**MEETING NOTES**  
**POW Comprehensive Cancer and Blood Disorder Centre**  
**14<sup>th</sup> September 2012**

Purpose	To brief the Randwick Council on Stage 2 of the POW CCBDC Development
Location:	Randwick City Council

**STAGE 2 DA - ELEVATIONS
STREET ELEVATIONS**

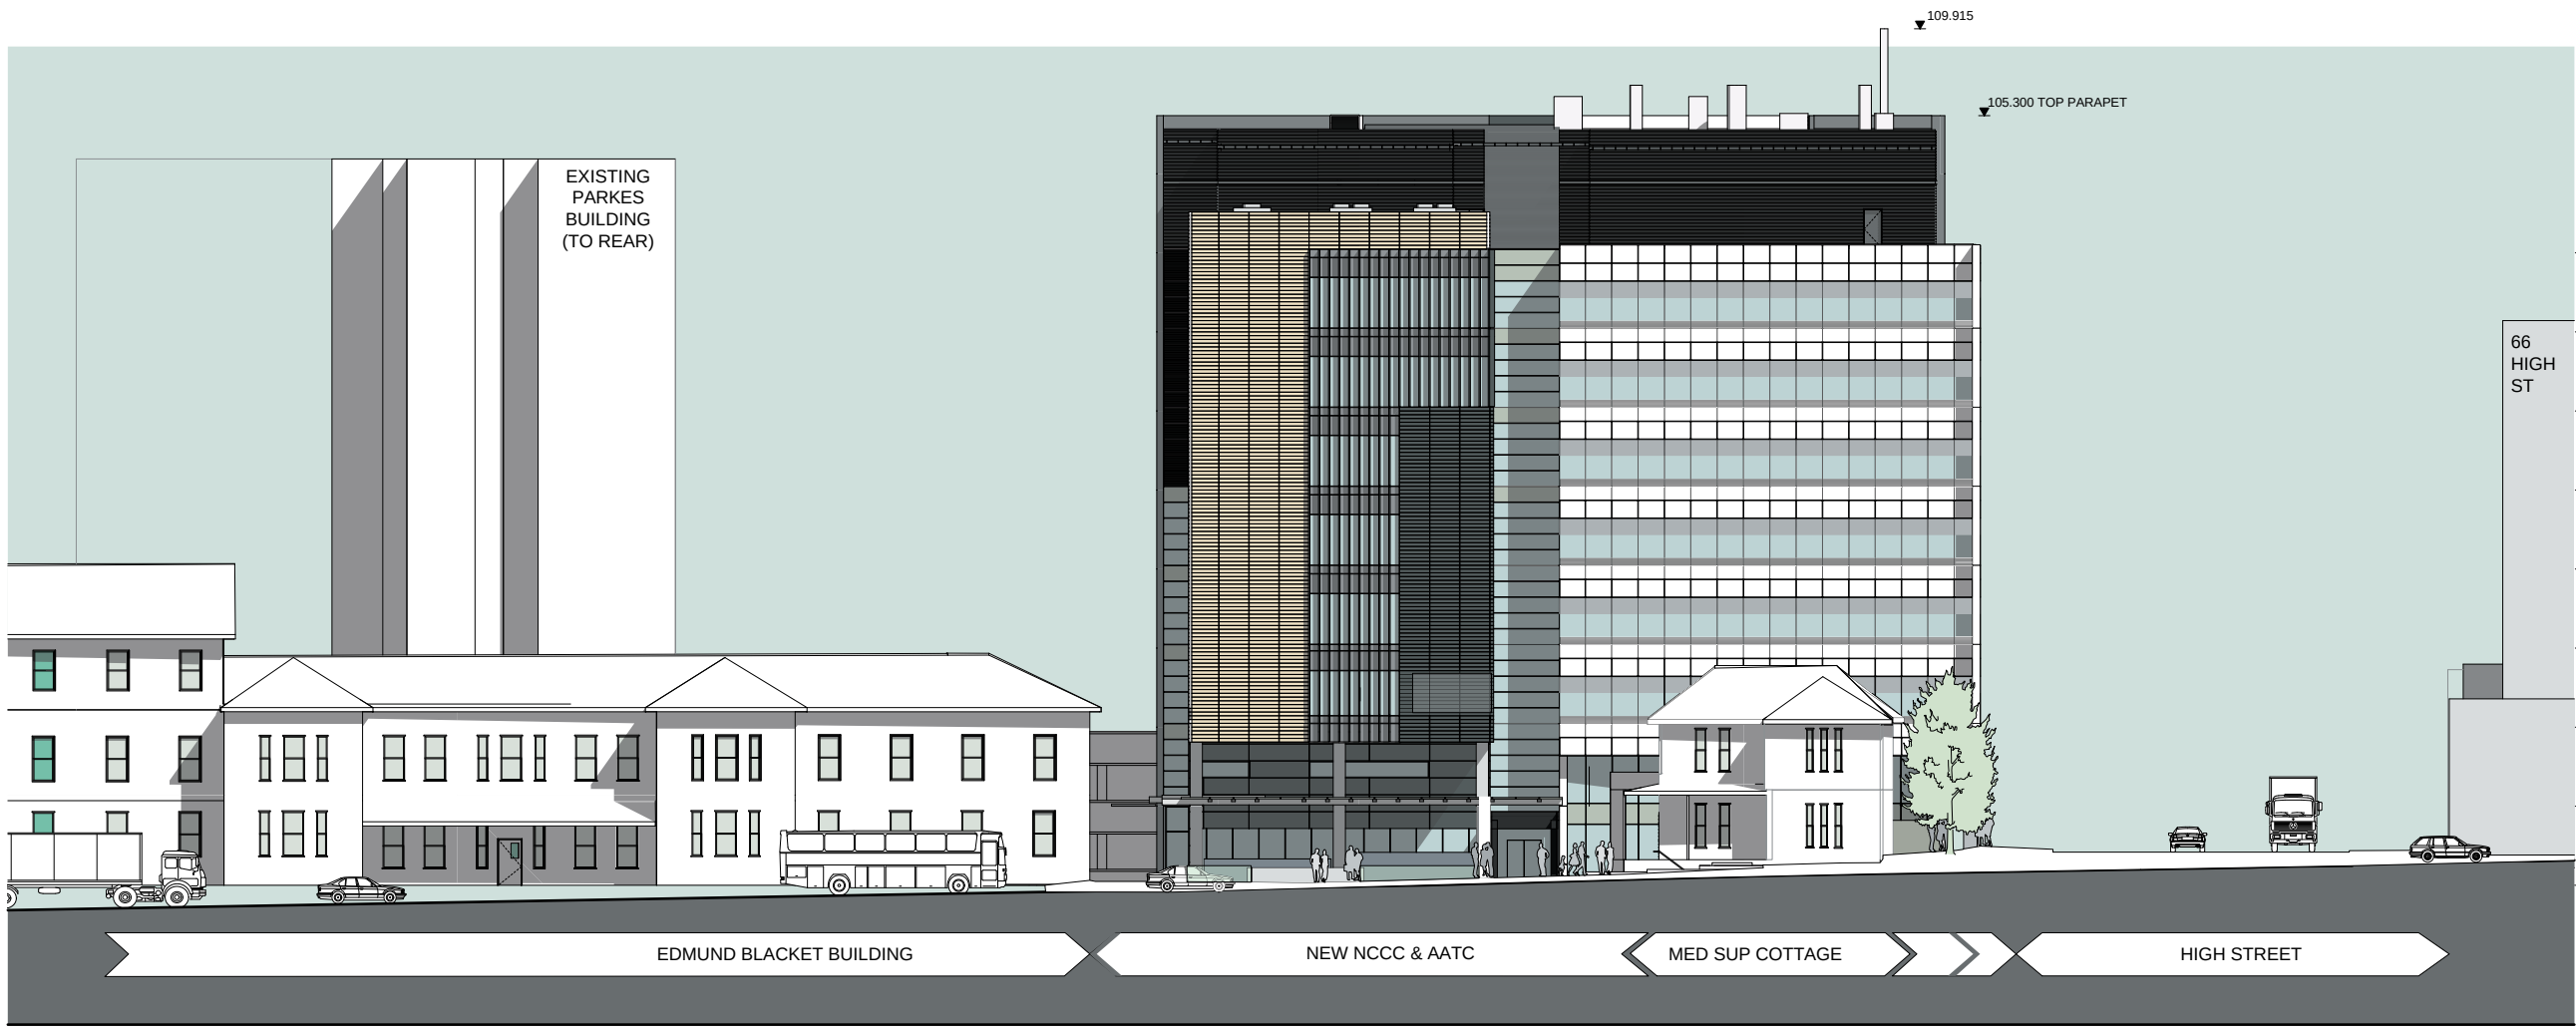
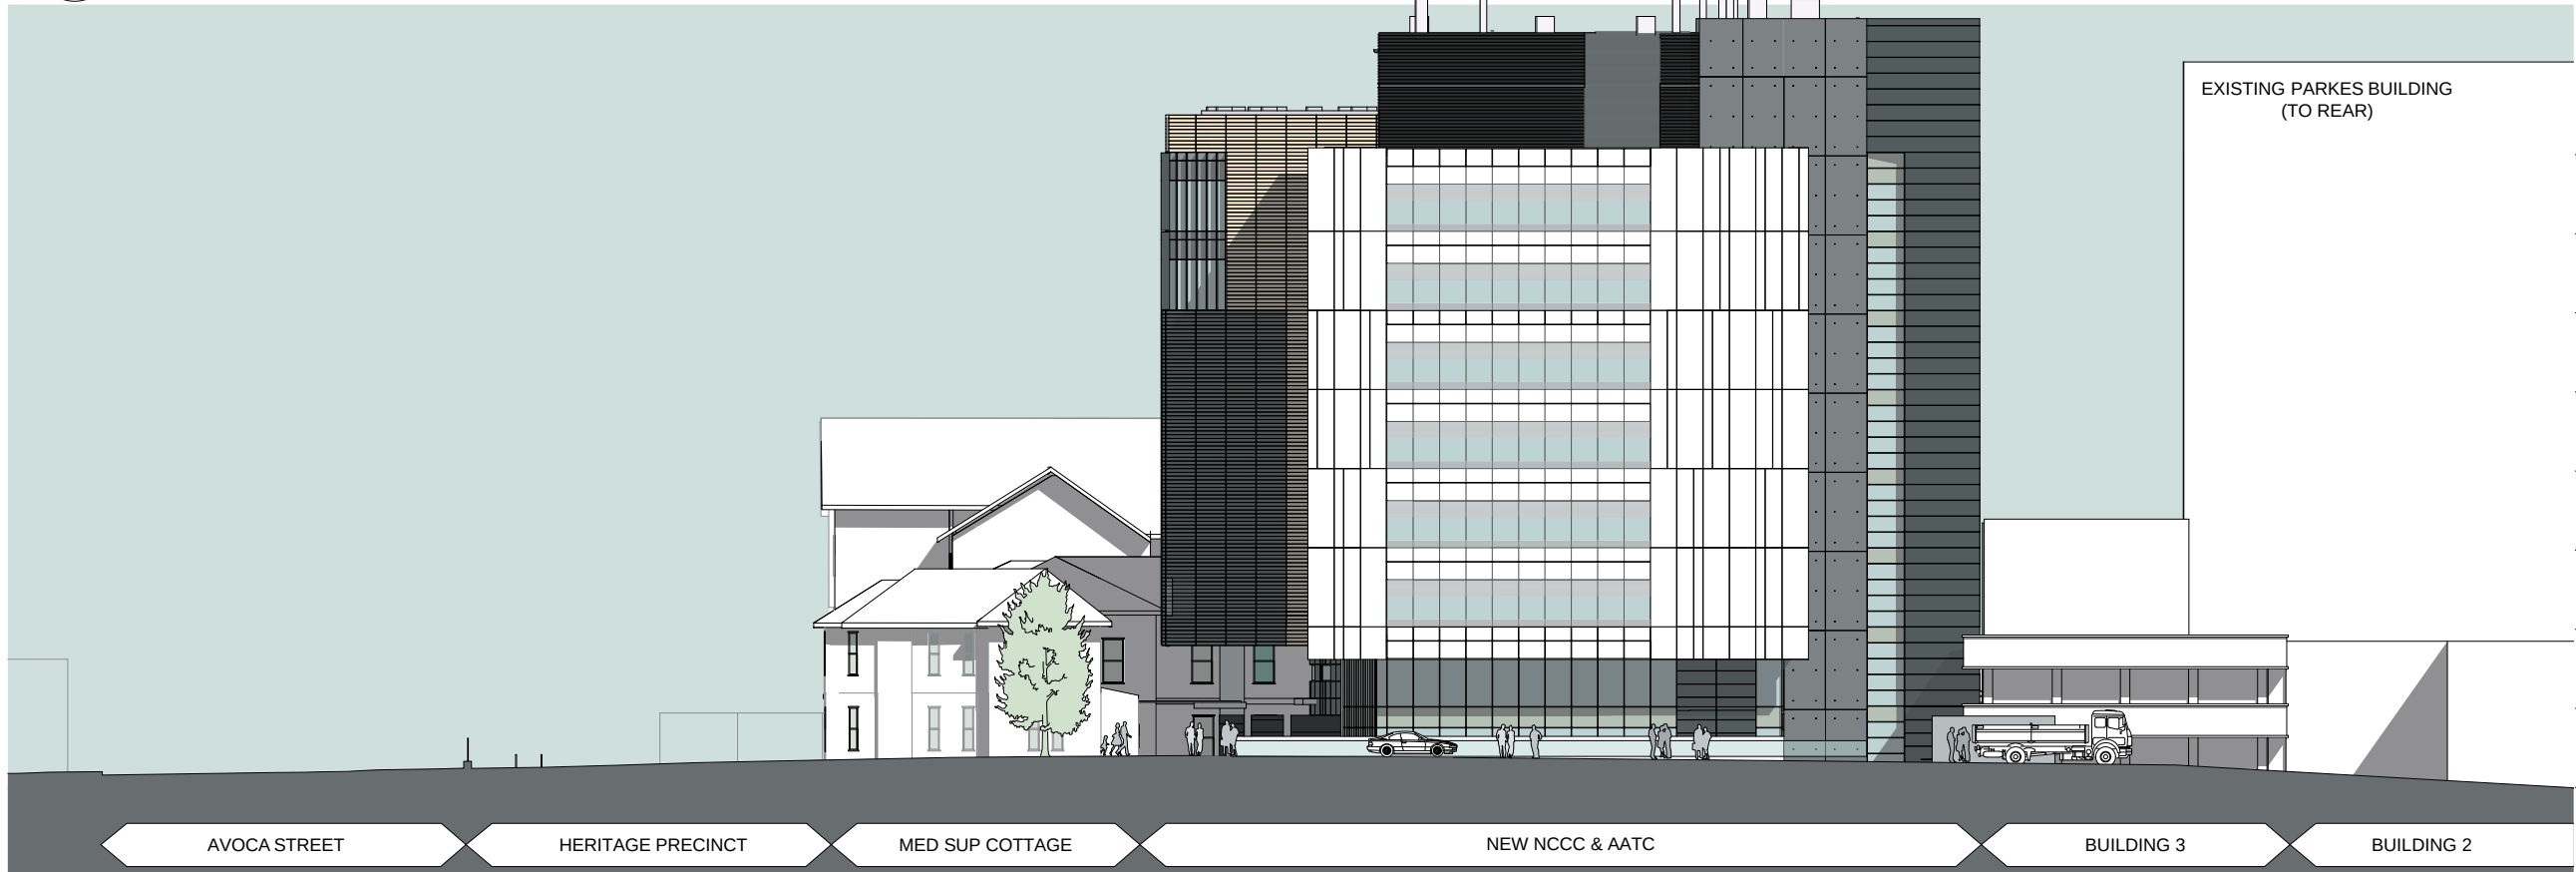
Generally not concerned about size of the building  
Comments related to relationship with the masterplan and the need to consider it in the application.  
Relationship to buildings across the road and shadow impacts.  
Agreed with improved landscaped comments from HO.  
Need to consider the light rail potential along high street.
